As follow up requested by the inspectors at the hearing on October 1st, please find below comments and information for Deadline 6 from myself on behalf of Bickenhill Village:

Thirdly as agreed we have investigated screening of the proposed main site compound from Bickenhill Village. Several villagers and I have walked the length of the village to identify hotspots where screening will be critical to avoid seeing right into the compound. We have drawn several conclusions based on marking 2m (the height of the topsoil stacks), and 3.6m (the maximum possible screening alluded to at the last hearing) on photographs at the Church Lane side at the top of the proposed compound field. Whilst this was not a rigorous scientific exercise it has allowed us to draw the following conclusions:

Drawing Title
INDICATIVE PROPOSAL FOR MAIN COMPOUND AND OFFICES FOR M42 J6 SCHEME

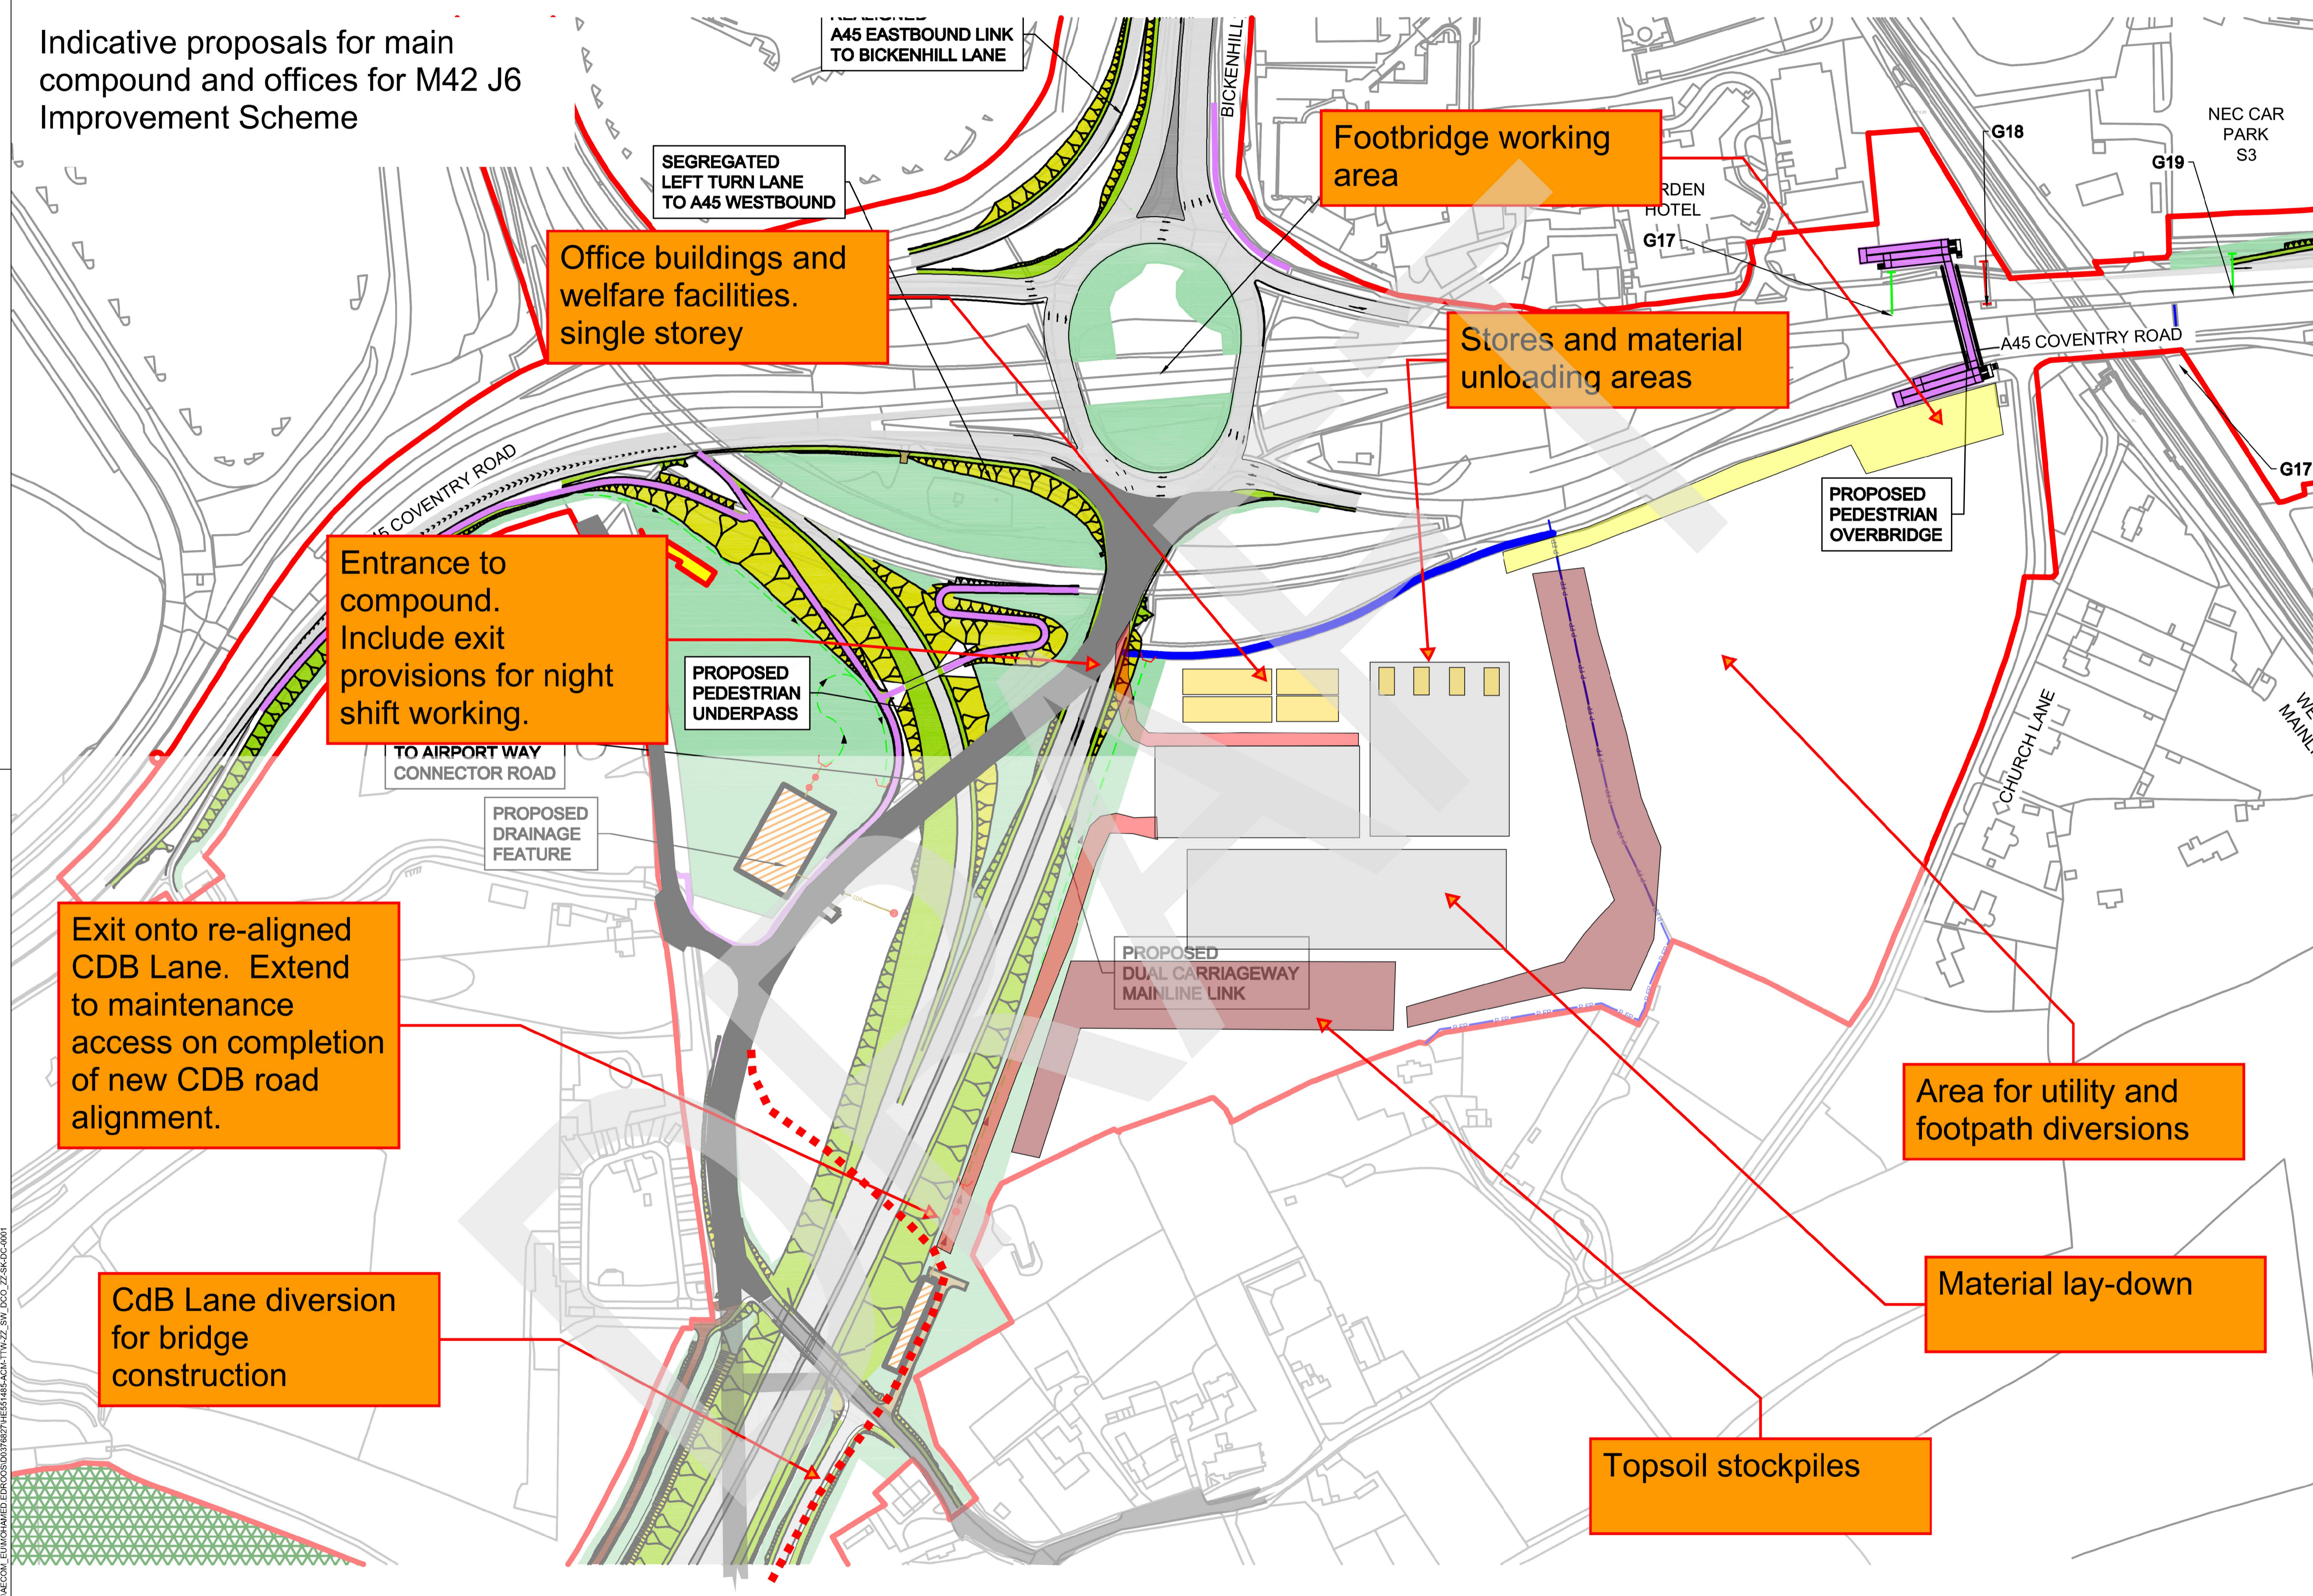
- Visual and acoustic screening will be required around the whole of the compound.
- There are areas where the 2m high topsoil stack might be sufficient- at the north end of Church Lane, depending on exactly how high up the slope the compound extends to.
- However at the view from Mr Cotterill and Mrs Burton's bedrooms 3.6m might not be sufficient, and certainly the view from the end of Pitt Lane would not be sufficient. The screening in this area will be most effective on the Church Lane side border of the main field-the further into the proposed main compound field the screening goes the less effective it will be due to the drop in elevation.
- We would also request further information from Highways England on what possible solutions might exist to address the pinchpoints where 3.6M might not be sufficient.
